Addendum No. 1

RE: Contract # C203908

Wake County (W-5522)

Pedestrian Tunnel At SR-1656 (Trinity Road) and SR-1658 (Youth Center Drive)

SHEET NO. **S-01**
 TOTAL SHEETS 31

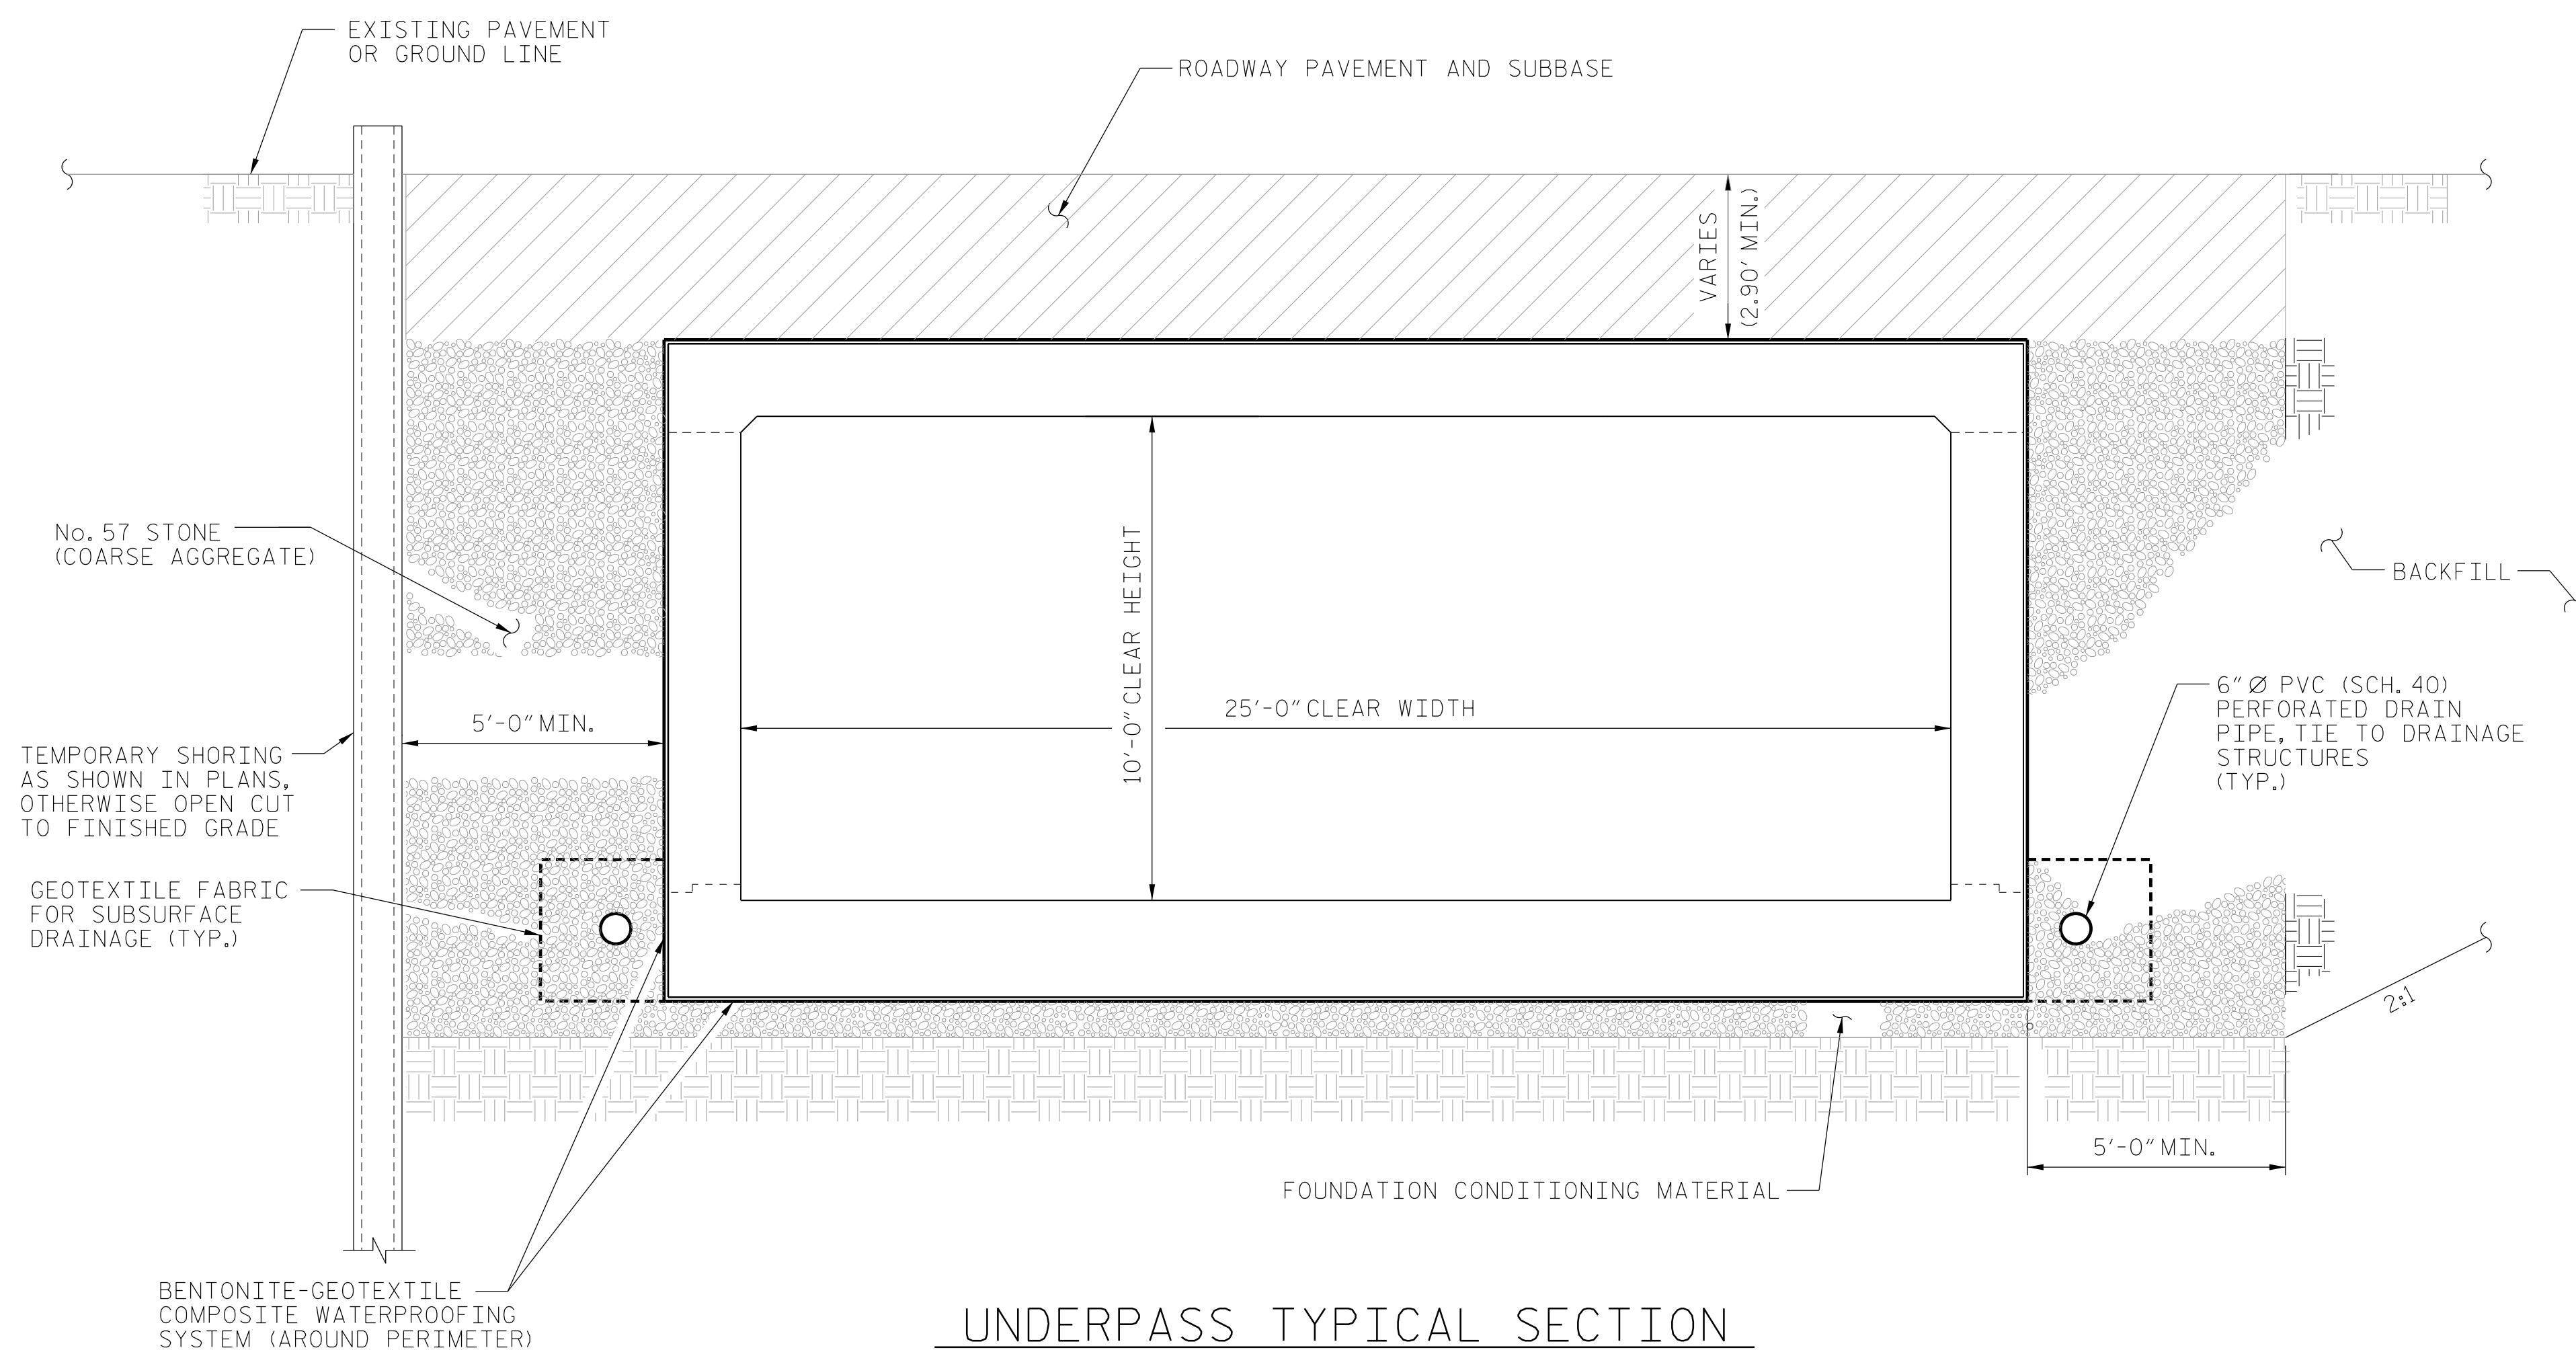
Sheet No.	Revisions
S-01	Revised to add the temporary shoring recommendation notes
